State of Washington
DEPARTMENT OF FISH AND WILDLIFE
South Central Region • Region 3 • 1701 South 24th Avenue, Yakima, WA 98902-5720
Telephone: (509) 575-2740 • Fax: (509) 575-2474

August 30, 2019

RE: WDFW Comments on SP-19-00002 Rampart Row

RAMPART ROW SHORT PLAT APPLICATION

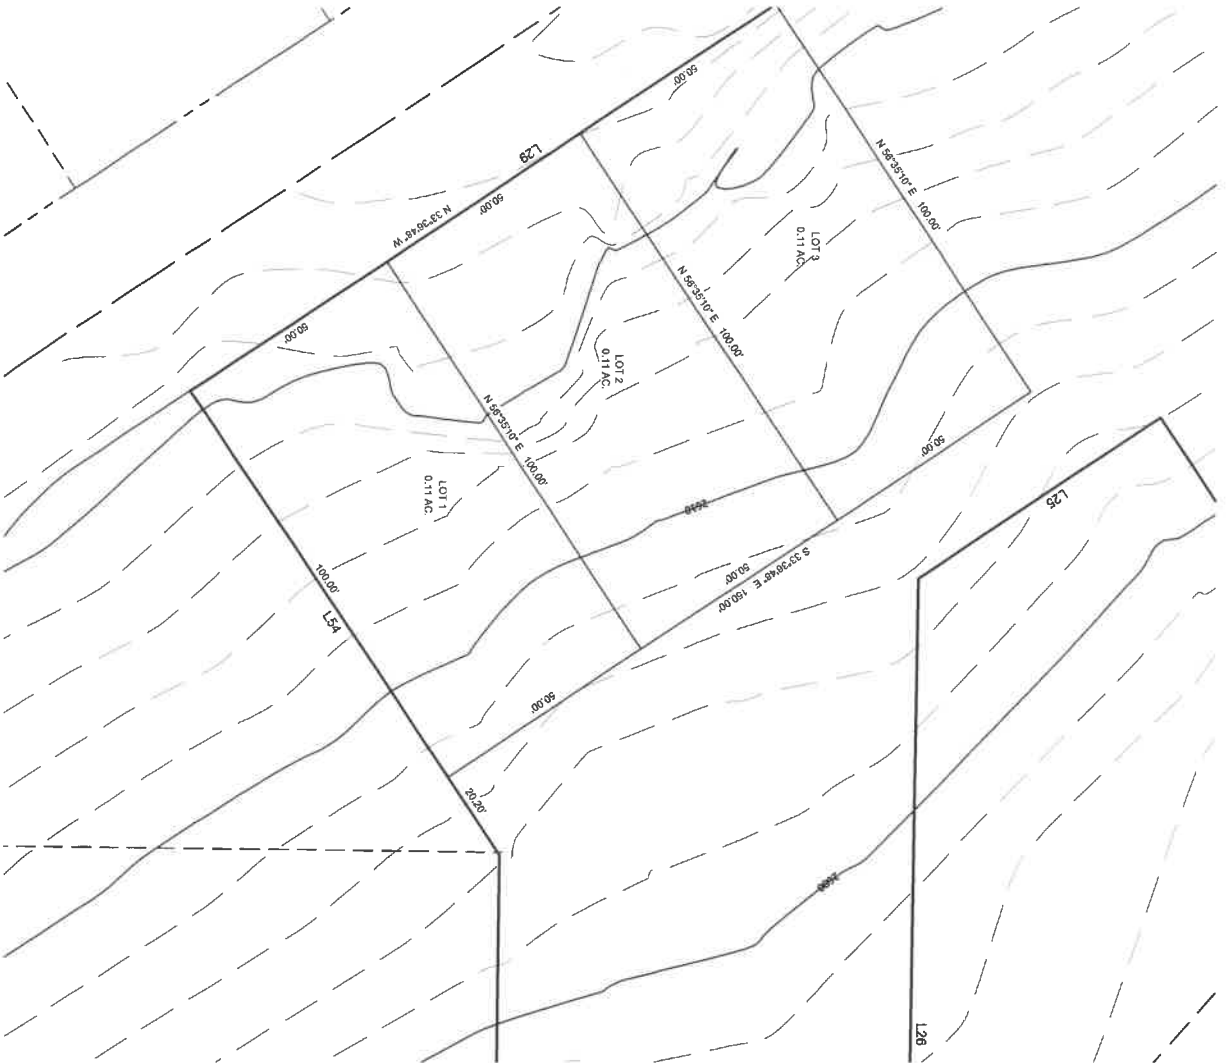
The materials submitted as part of the application only include mapped hydrological features; there is no indication that a physical survey has been conducted. Thus, the submitted materials do not provide WDFW with enough information to comment on whether this application would impact critical areas or not.

- 1. WDFW requests that an on the ground survey report detailing streams and wetlands present on the site be conducted by a qualified biologist prior to approval of the short plat.** A qualified biologist is a person who has demonstrated experience in stream and wetland delineation and in the case of wetland delineation, they should be certified according to Department of Ecology standards.

- 2. WDFW further requests that we be sent a copy of the report so that we may review and provide comments to Kittitas County prior to approval of the short plat.** The review of the report would allow WDFW to properly comment on the proposal for critical area impacts.
